**Highways England: A303 Amesbury to Berwick
Down Project, Development Consent Order
Application**

Scheme Reference: TR010025

**Summary of oral submissions at ISH 10:
Flood risk, groundwater protection, geology and
land contamination**

**The Stonehenge Alliance
(Reference No. 2001870)**

Figure 2 Chalk Stratigraphy with Tunnel and Chalk Rock Elevations (adapted from Mortimore (2012))

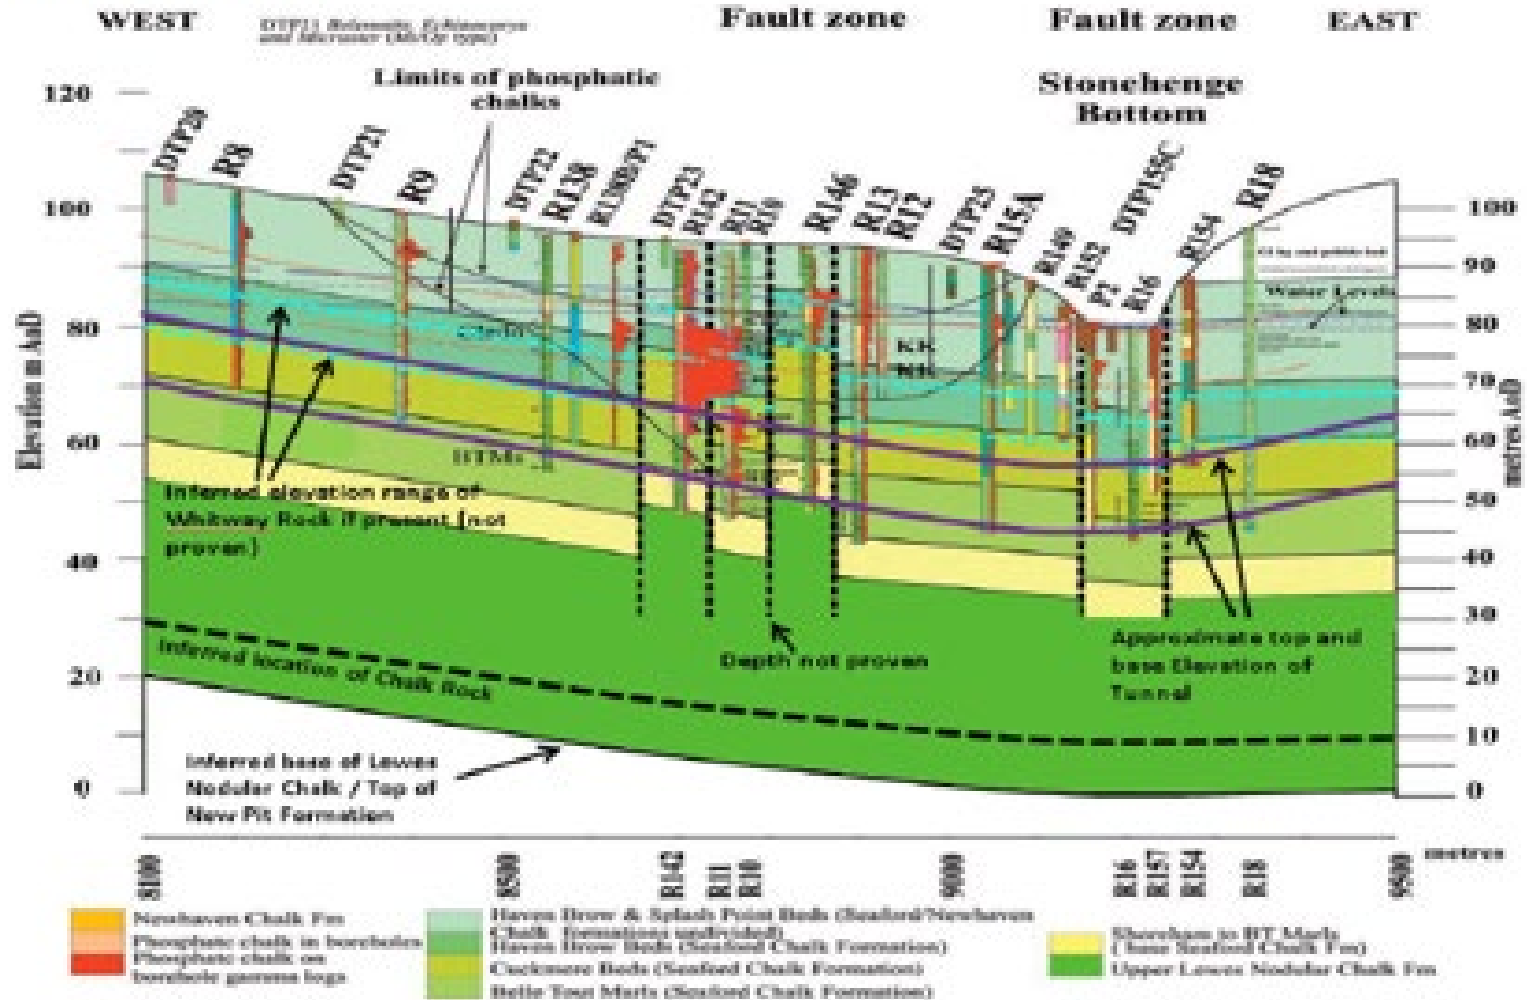
7. [Slide 10] The geological cross-section produced by Highways England at Fig.2 in their Deadline 3 *Implications of 2018 Ground Investigations to the Groundwater Risk Assessment* (REP3-018) (reproduced below) is noteworthy. The section shows where the Whitway Rock was expected to be and the proposed tunnel line. The geology in Stonehenge Bottom is obviously extremely complicated, with massive vertical fractures. It is proposed to place the tunnel within or partly within the Whitway Rock and the horizon of high permeability above it. See levels in Slide 13: Boreholes R13 and R11, where I interpret the Whitway Rock Horizon to be at the tunnel soffit level as proposed.

In examining the detail of groundwater and lithological data relating to the Whitway Rock Horizon, it was noticed that Highways England had used a dated figure (Fig.2), attributed to Professor Mortimore in his 2012 Glossop Lecture (see reference and Fig.2 reproduced below). It remains uncertain if the AWM groundwater modellers have superimposed the correct profile of the proposed tunnel (as defined in the HEng A303 Amesbury to Berwick Down Project Documents APP-010 and APP-019 (Engineering Section Drawings) on their Figure 2.

The groundwater levels and postulated zone range of the Whitway Rock horizon are also problematic (see figure below) as explained in Dr Reeves' presentation to the hearing.

In view of a presumably much more recent (and radically different in its eastern part) section drawing of the geology across Stonehenge Bottom by Professor Mortimore et al. (2017, Fig.16a; reproduced for comparison at end of this submission), there is no obvious reason nor any explanation why Mortimore's 2012 section is used and represented in AWM Report No. TR010025 Document 8.23 – Implications of 2018 Ground Investigations to the Groundwater Risk Assessment (REP3-019) republished with tracked changes, dated 31.05.19):

Borehole R20

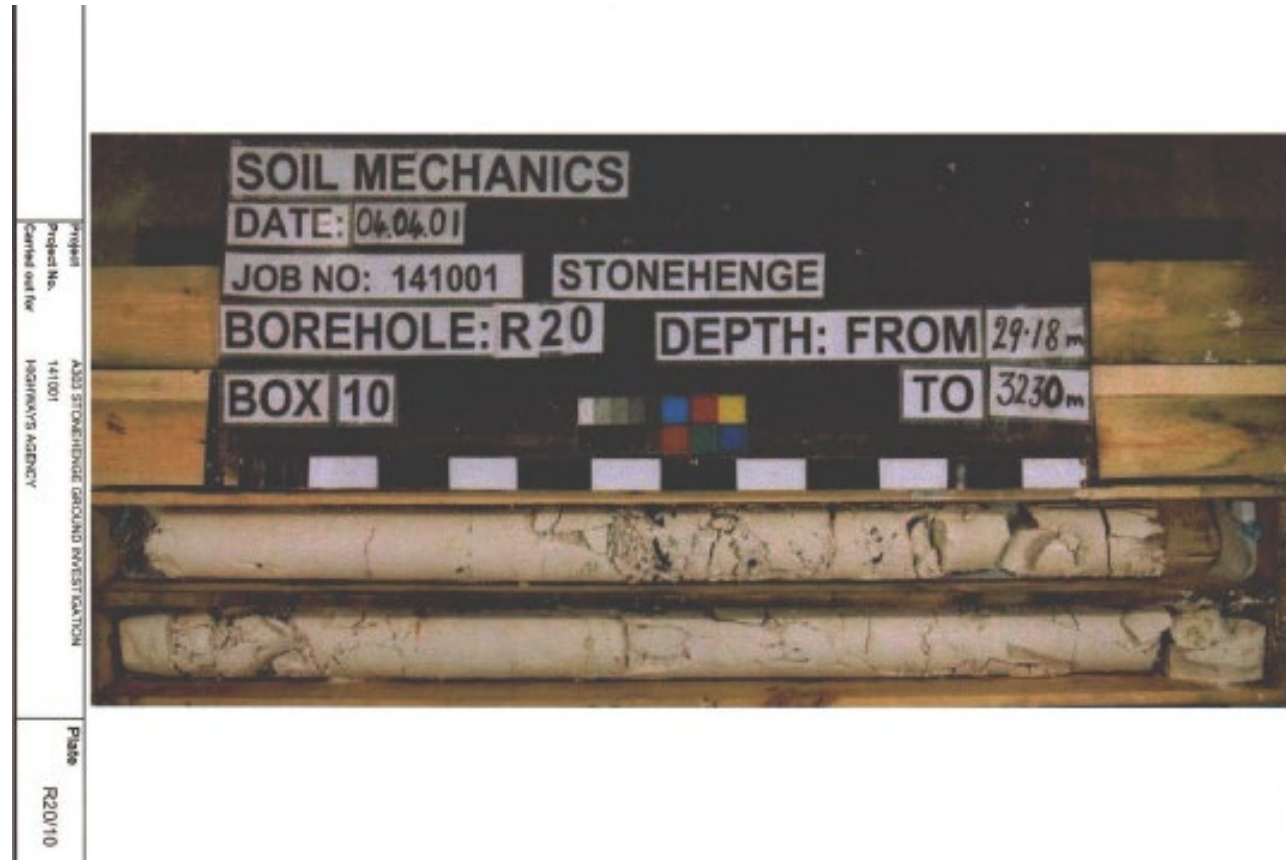
12. [Slide 14]. This image of a core sample (R20) shows, in my opinion, the heavily fractured zone above the location of the Whitway Rock, where it is more evident/developed in the western area of the Salisbury Geological Survey.
